From: Nathan Hanks [REDACTED]
Sent: 12 December 2018 09:48
To: Anita Gardner
Subject: RE: Bluebird Cafe, Ferring FG/159/18/PL

Taking these points in turn:

I refer to our recent discussions in respect of the above planning application, and specifically the comments you have received from 'Transport Planning Associates' (TPA), contained in their Technical Note (*referenced 1811-18/TN/01 and dated November 2018*).

02 Proposed Site Plan
1002 Scale: 1:200

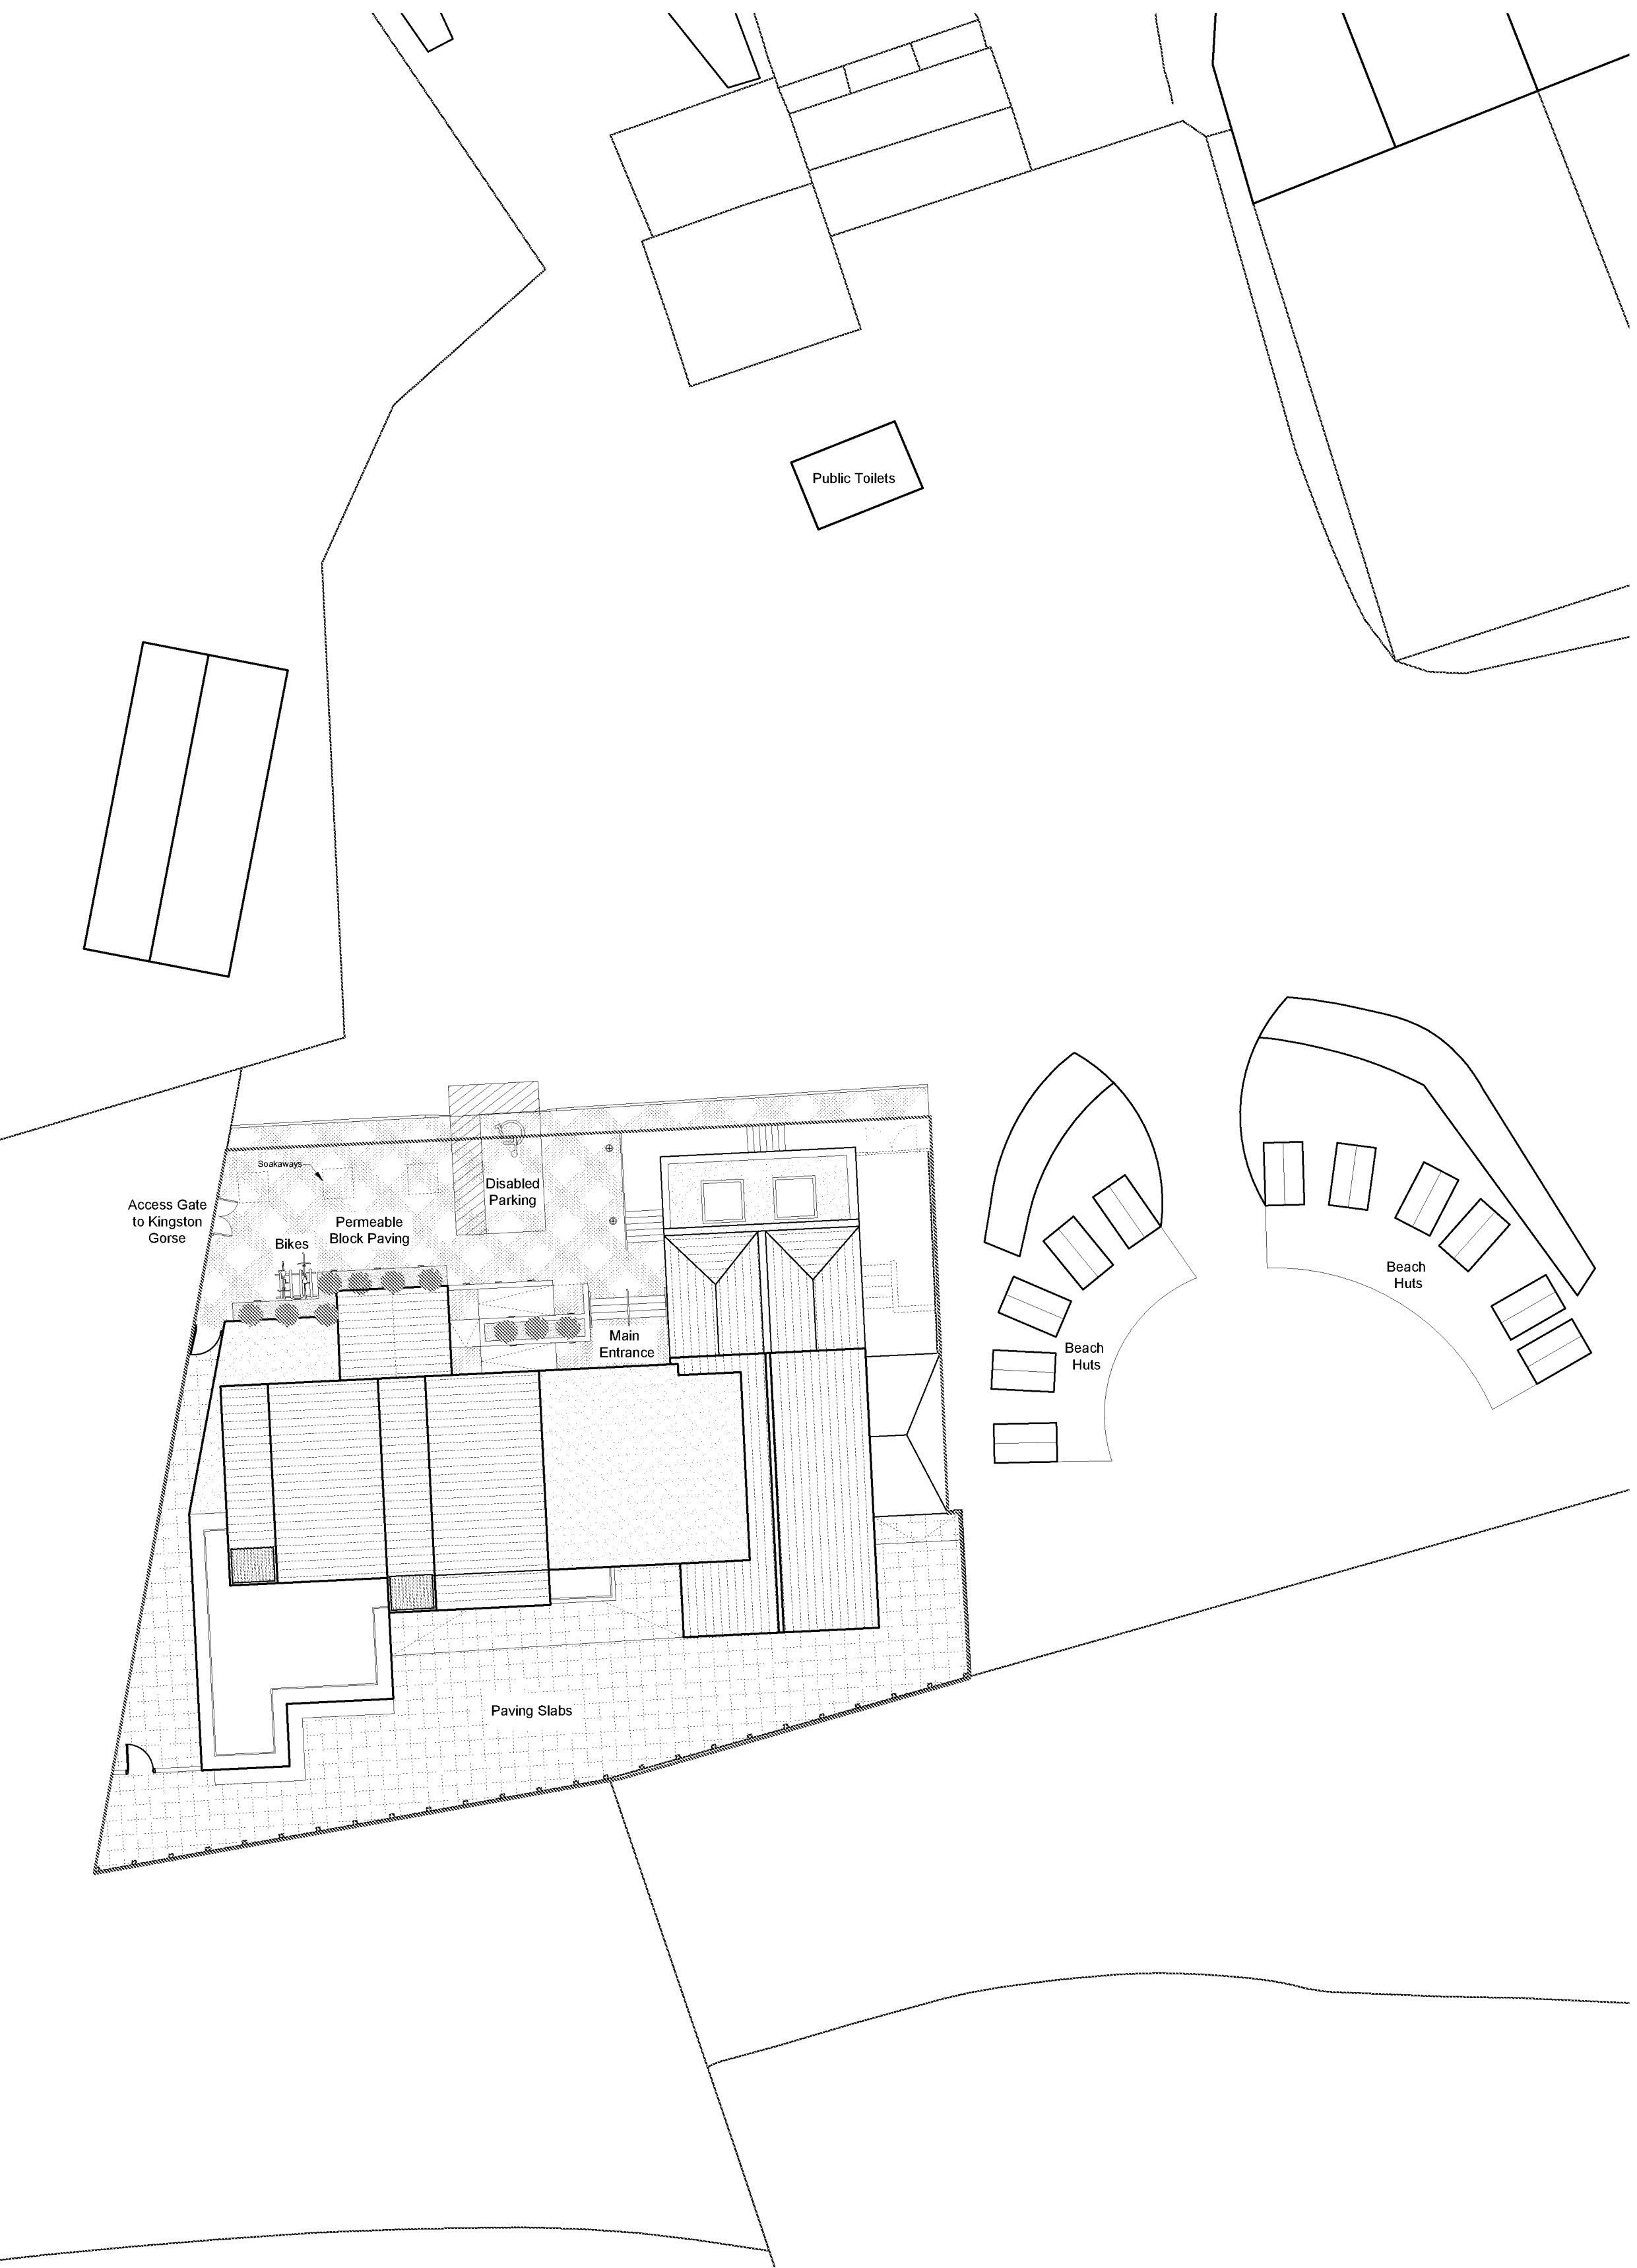
7. Should the applicant consider that they can accommodate all café parking on land within their ownership, they should show how this will be achieved on a plan, with a Car Park Management Plan illustrating how this arrangement will be managed.
